Application No: A/130/21/PL

Recommendation Report for Planning Permission

LOCATION: 16 Pine Trees Close
Angmering
BN16 4LT

PROPOSAL: Demolition of existing garage, conversion of extension (approved under A/66/21/HH) to 1 No. 2 bed dwelling, provision of 4 parking spaces and cycle/refuse storage. This application is within CIL Zone 2 and is CIL liable as new dwelling.

04 PROPOSED FLOOR PLAN
SCALE 1:50 @ A1

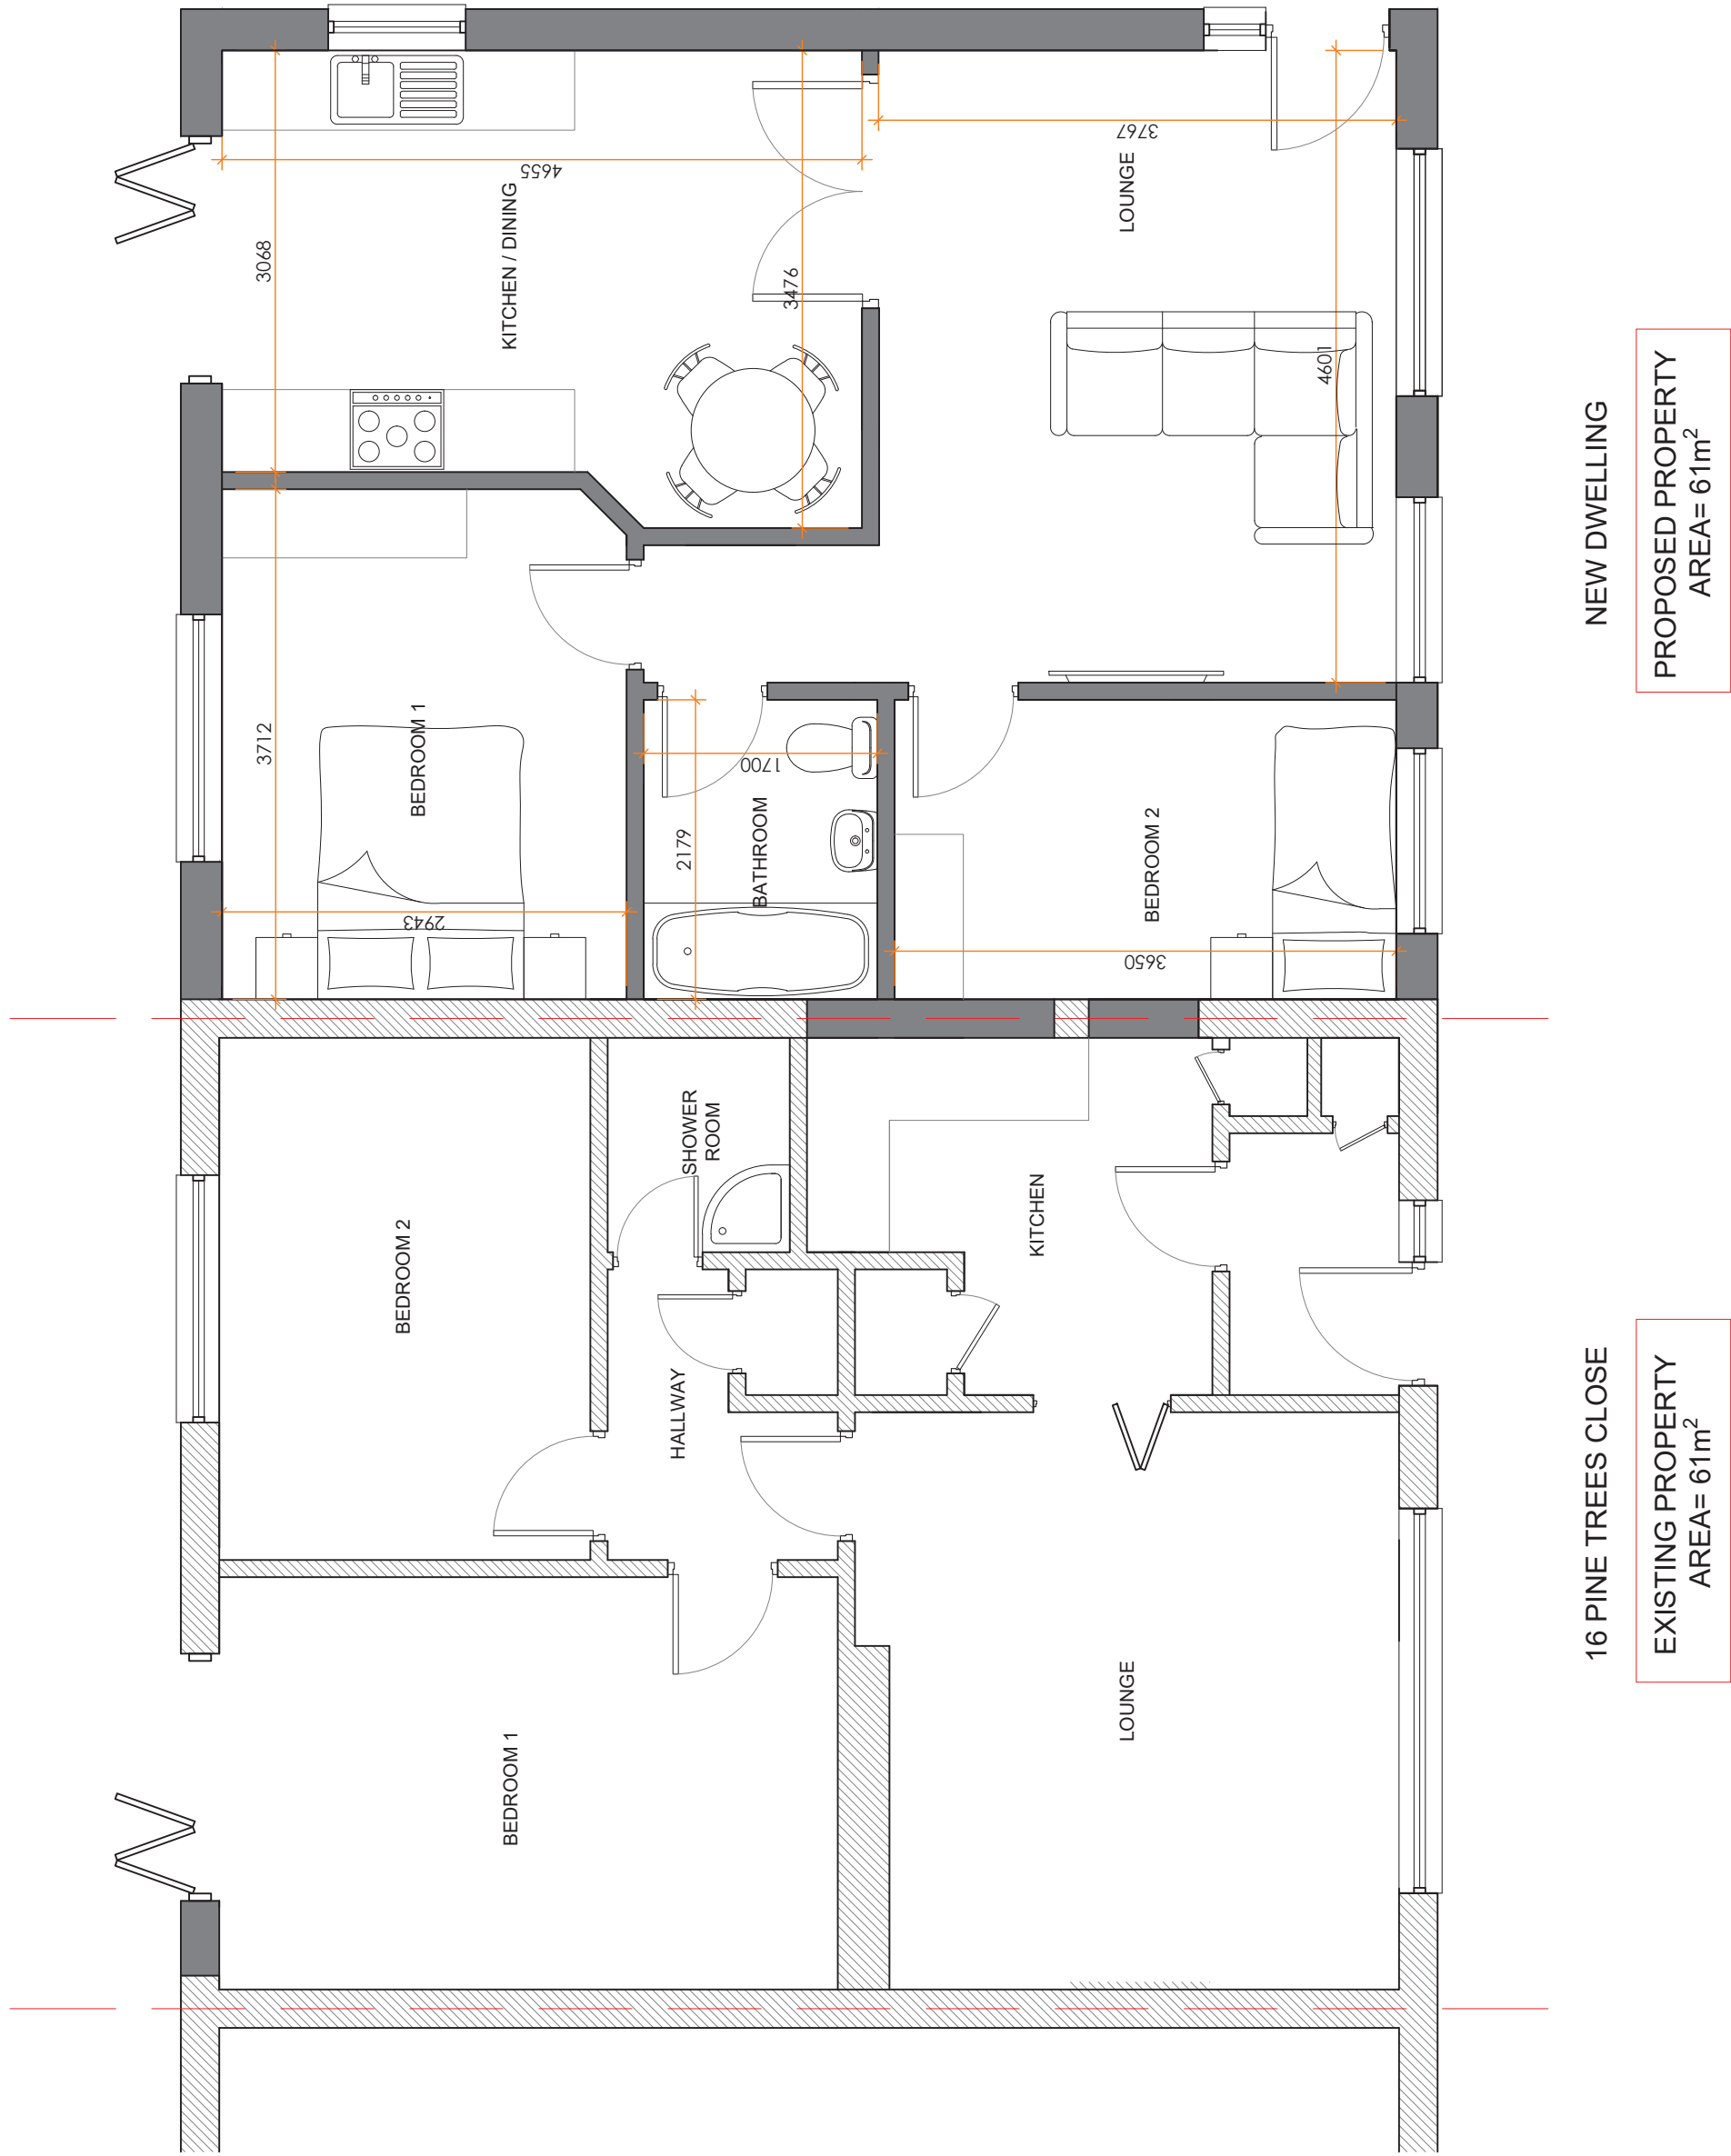
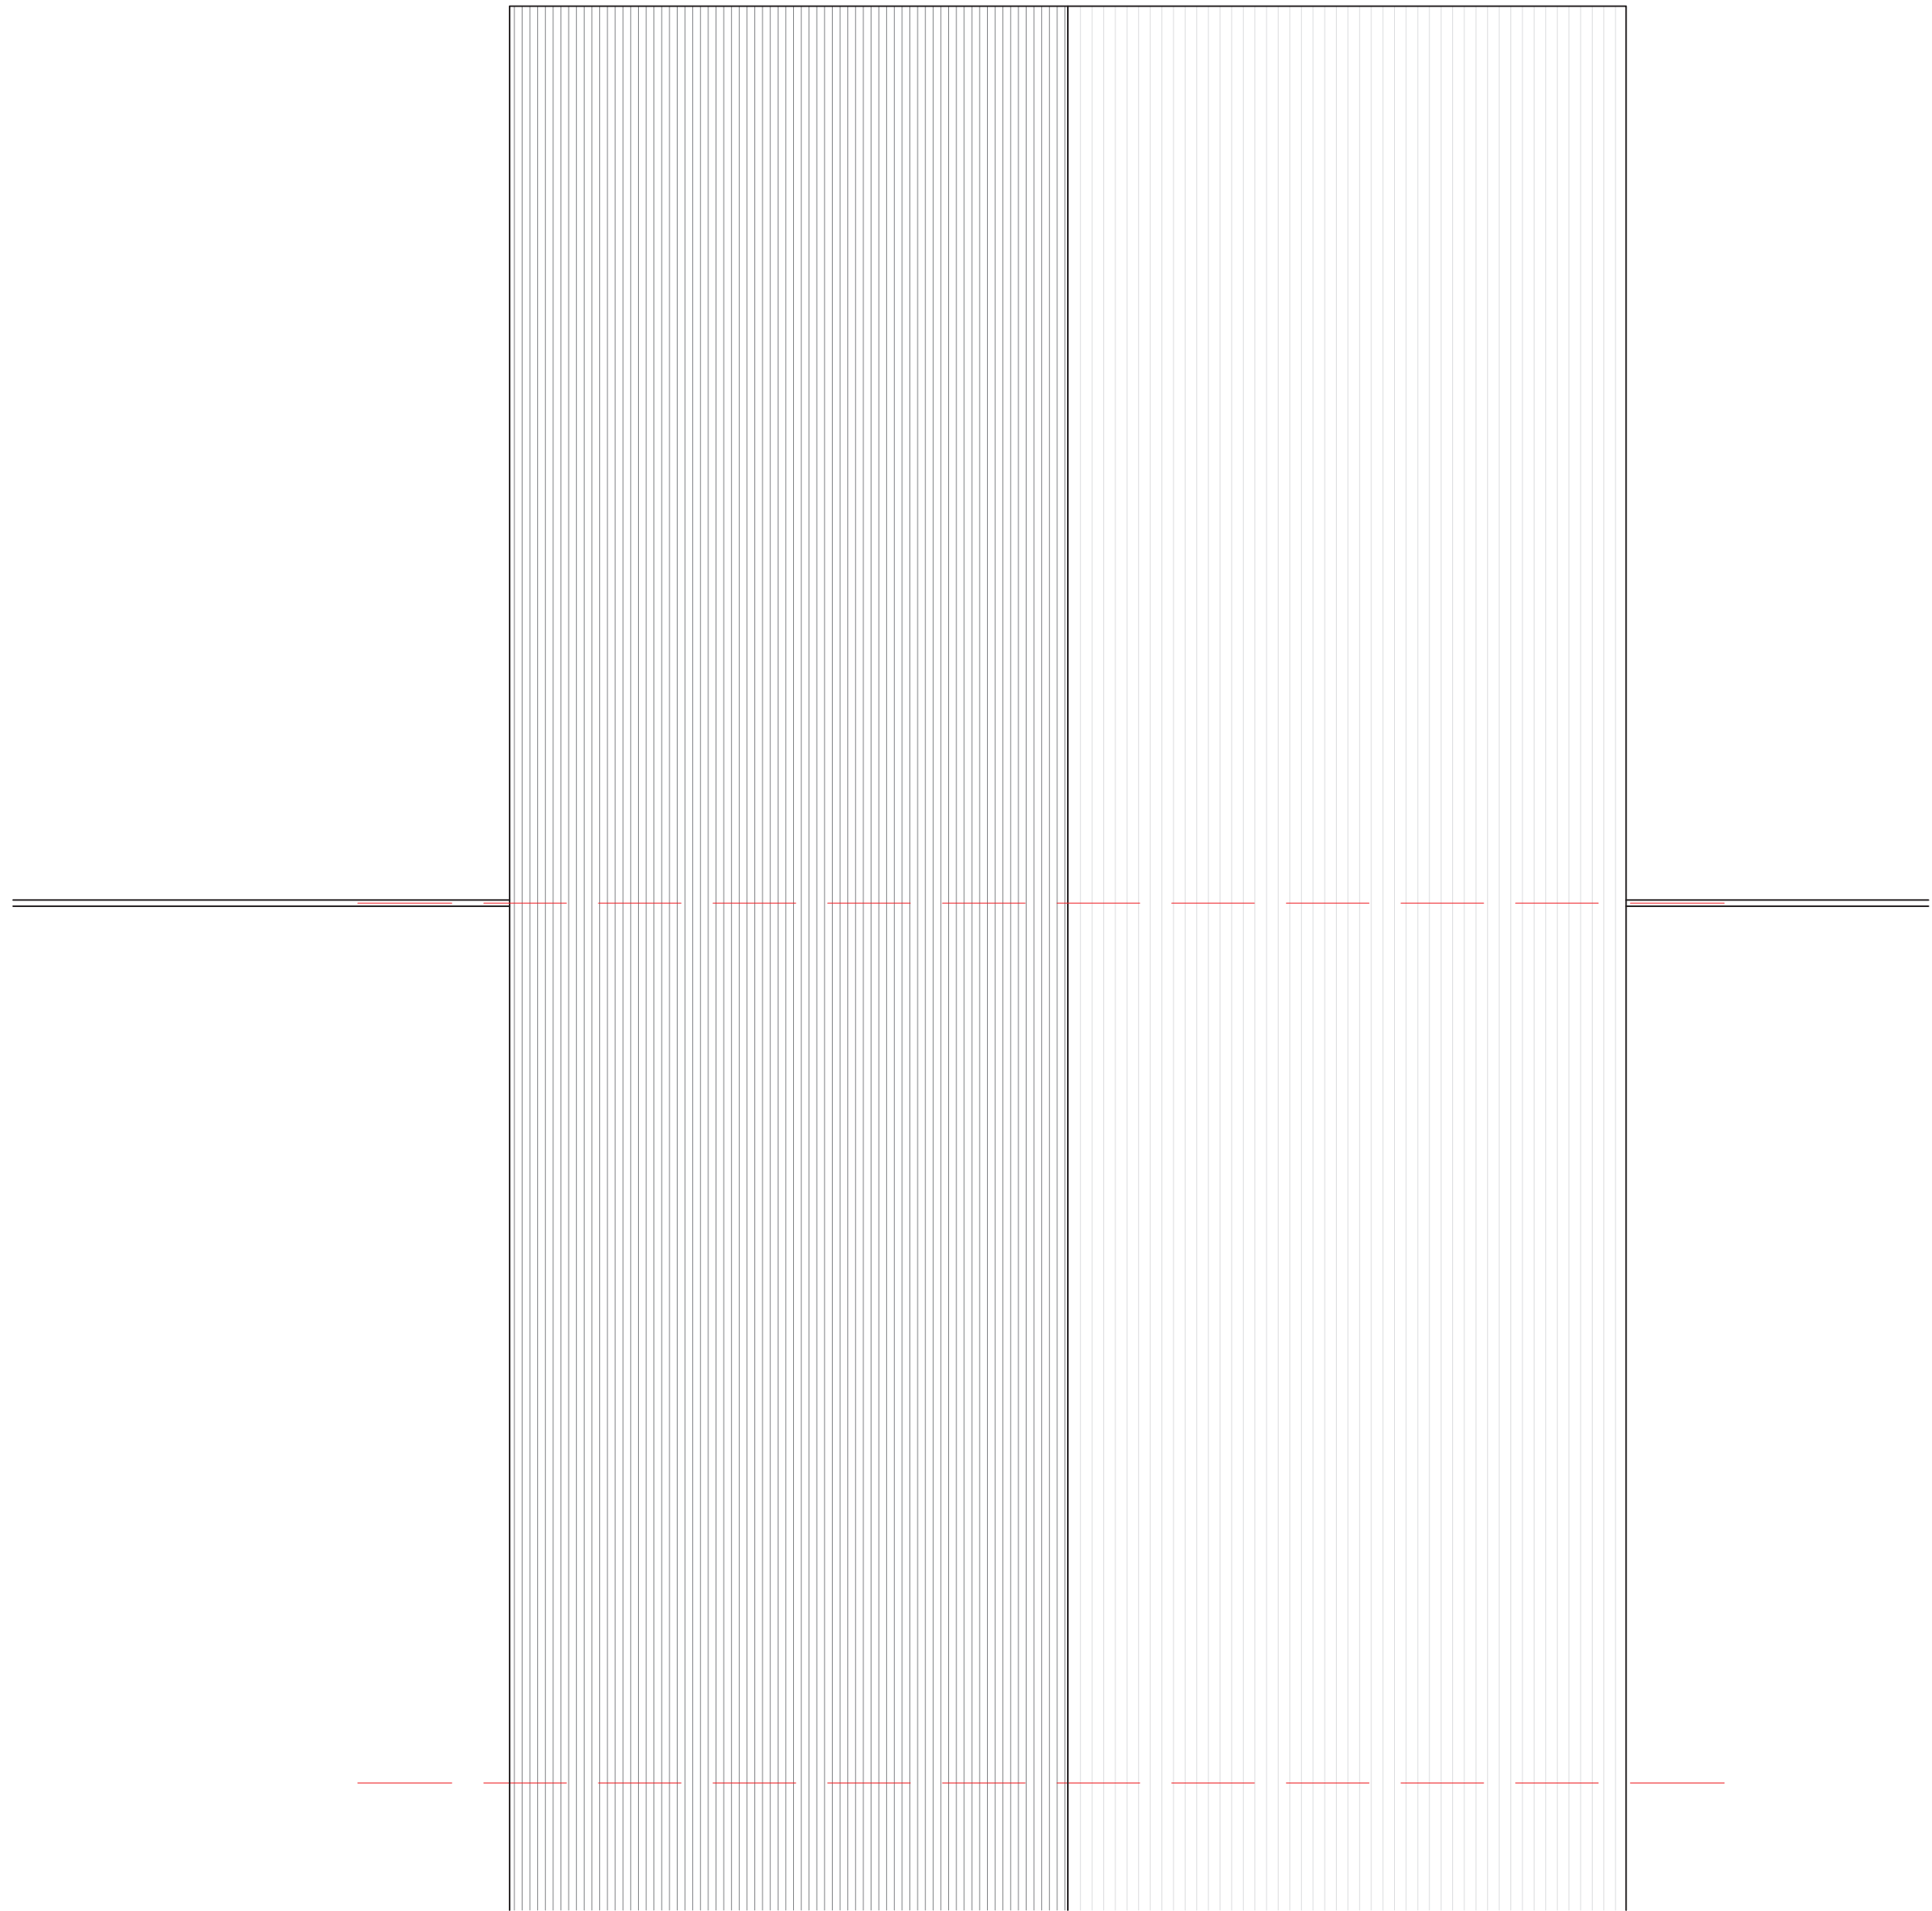
The floor plan of the single storey extension where it specifies the number of bedrooms and the square metres of floor space has been cross referenced with the Nationally Described Standard table (NDSS Table 1). The minimum gross internal floor area of the single storey extension complies with Policy D DM2 of the Local Plan and meets the NDSS requirements.
